Lr.No. D.Die. A1/19240/90.

Sub: MMDA - Planning Permission - Construc-  
tion of Residential building in Plot No.  
9A & 9B at S.No.343/2 part of Kodambakkam  
Village - Approval - Regarding.

3. The approved plans are numbered as planning permit No. A/180/91 and 3 copies/sets of the same alongwith the copy of the planning permit are enclosed herewith for taking further action in this regard.

ground floor plan

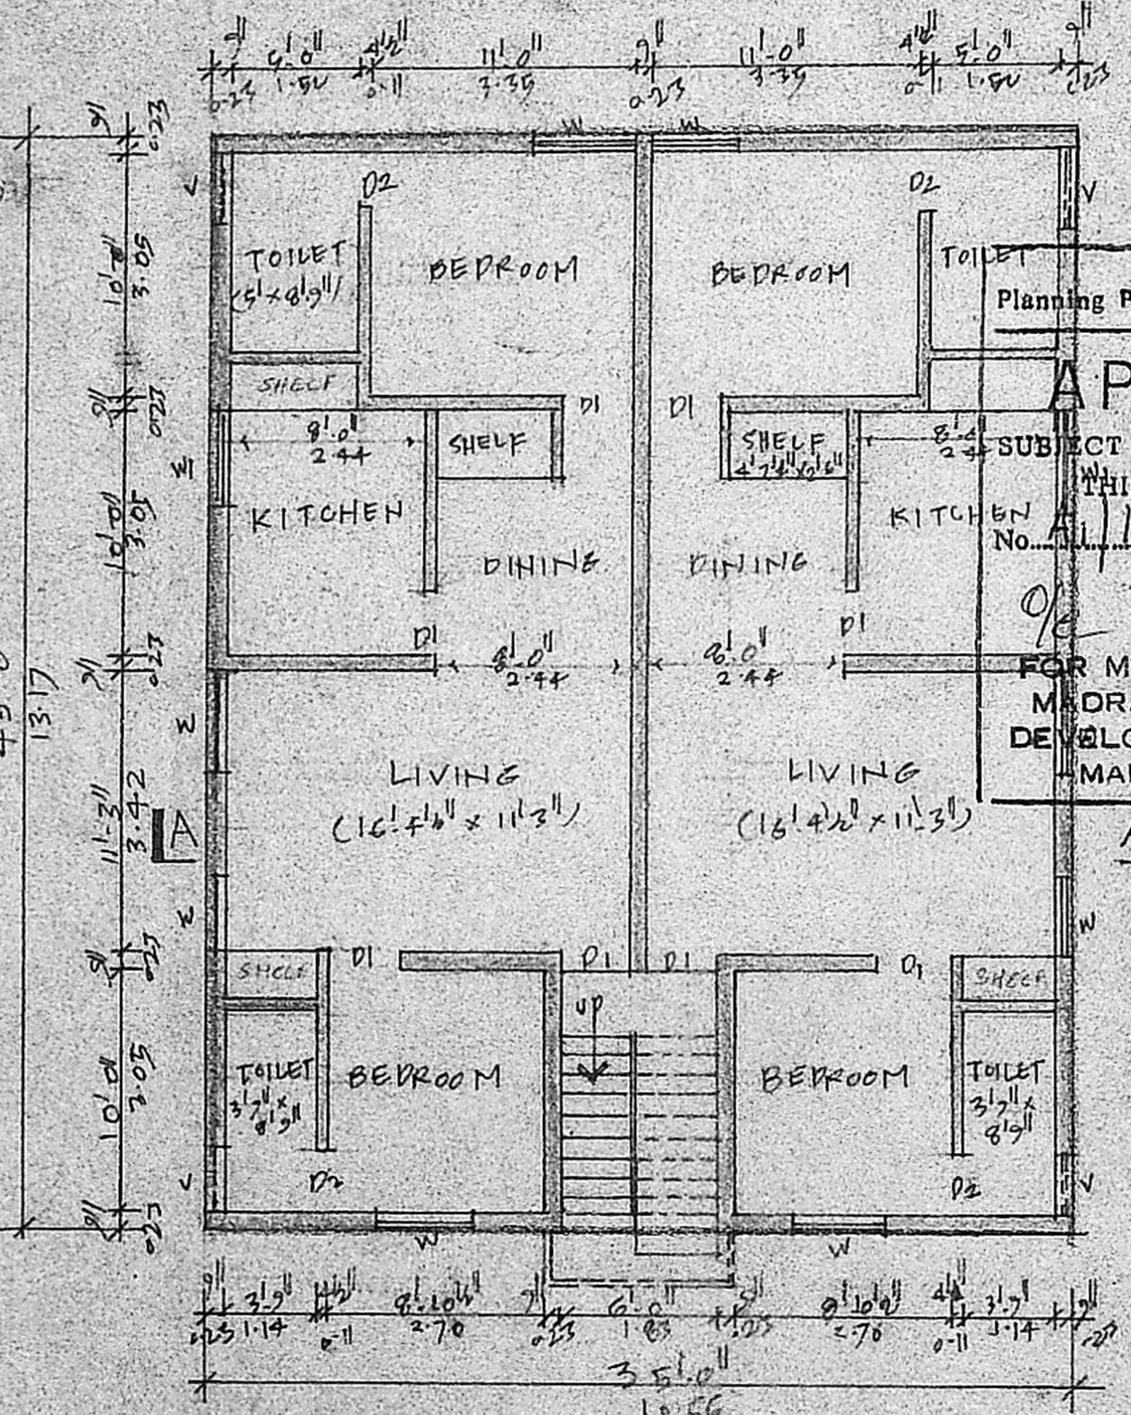
The planning permission proposal received in the reference cited for the construction of Ground + First Floor residential building in Plot No.9A & 9B, Kethaji Nagar, Jaferkhanpet at S.No.343/2 part of Kodambakkam Village was examined and found that the planning permission for the same is issuable by relaxing Stair case landing on Front Set Back space and subject to the condition that --
